Addendum

Project Name:	Kariong Sand and Soil Supplies - Air Quality Assessment – RTS
Reference:	18.1021.L2V4

The following letter has been prepared by Northstar Air Quality Pty Ltd on behalf of Jackson Environment and Planning Pty Ltd and provides a response to submissions (RTS) associated with the Air Quality Impact Assessment (AQIA) which was prepared to support the Kariong Sand and Soil Supplies EIS (SSD 8660).

PROJECT:  
**PROPOSED KARIONG SAND & SOIL SUPPLIES FACILITY - SSD8660**  
DETAILED SECONDARY PROCESSING BUILDING PLAN

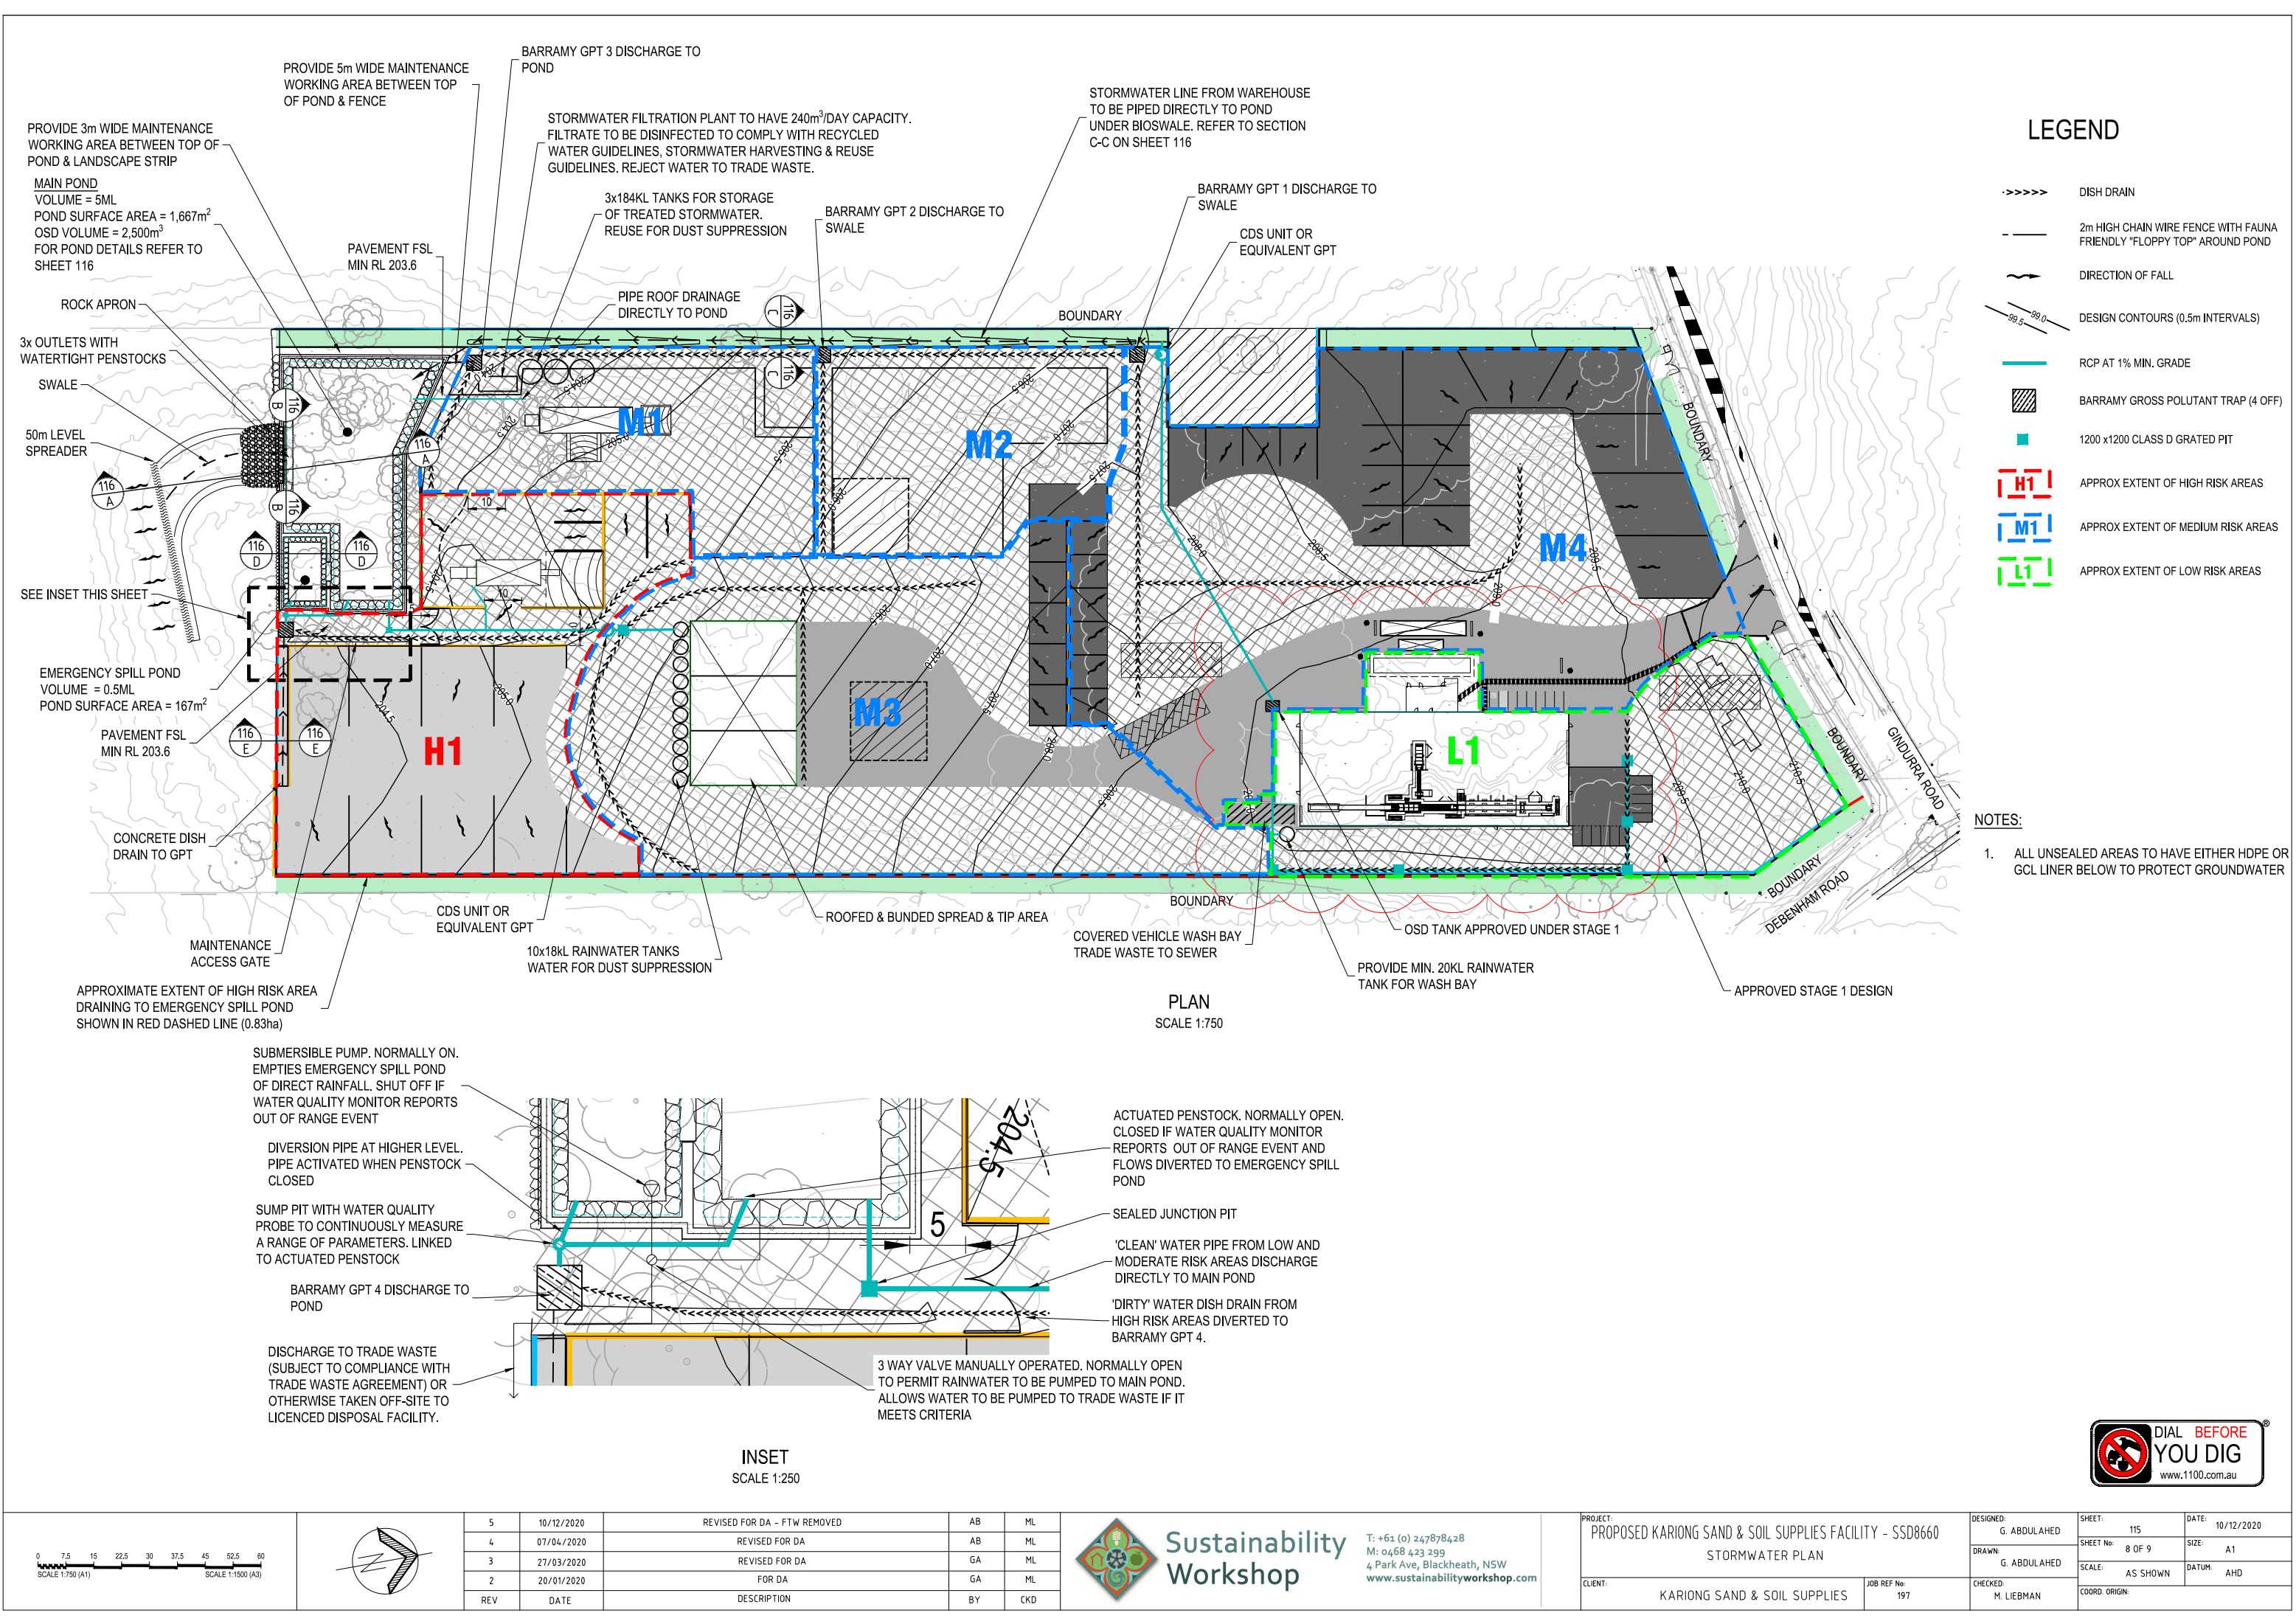
The EPA considers that partially enclosed structures, such as the ones proposed in the AQIA (V2, 2020), are not consistent with best practice emission control design. The achievable level of dust control using the proposed designs is expected to be low compared with a fully enclosed building, particularly under certain meteorological conditions and wind directions (dependent on the orientation of the structures). There is also no site representative meteorological data available which could be used to inform the optimal orientation of the building structures.

Activities associated with material processing, such as crushing, screening, grinding and shredding have the potential to significantly increase the potential for dust emissions from a facility and must be appropriately managed and mitigated. The use of best practice engineering controls is recommended.

The EPA considers that the proposed engineering controls could be further improved using fully enclosed structures and should be considered in the final design stages for the proposal.

Prior to project determination, the proponent should undertake a detailed feasibility assessment of engineering controls for controlling dust, including a benchmarking study against best practice dust management. The assessment must consider the adoption of fully enclosed structures around all key waste processing activities.”

The project has been redesigned to include full enclosure around all materials processing activities. These include:

Shredder/mulcher:

- full enclosure of the shredding/mulching activities in a treated steel sheet-clad (e.g. Colorbond®) building. Sliding doors allow access if required and will remain closed during operation;
- drop rubber curtain between the loading hopper and shredding/mulching activities to contain particulate within the building;
- inclusion of dust misting system inside the shredding/mulching building;
- full enclosure of the conveyor from the shredder/mulcher to the product receiving bunker; and,
- Enclosure of the product receiving bunker with concrete block walls, Colorbond® roof and a rubber curtain for front end loader access.

Crusher/screen:

- full enclosure of the crushing/screening activities in a Colorbond® building. Sliding doors allow access if required and will remain closed during operation;
- drop rubber curtain between the loading hopper and crushing/screening activities to contain particulate within the building;
- inclusion of dust misting system inside the crushing/screening building;
- full enclosure of the conveyor from the crusher/screen to the product receiving bunker; and,

- enclosure of the product receiving bunker with concrete block walls, Colorbond® roof and a rubber curtain for front end loader access.

Plans of these control measures are included as **Appendix A** to this letter.
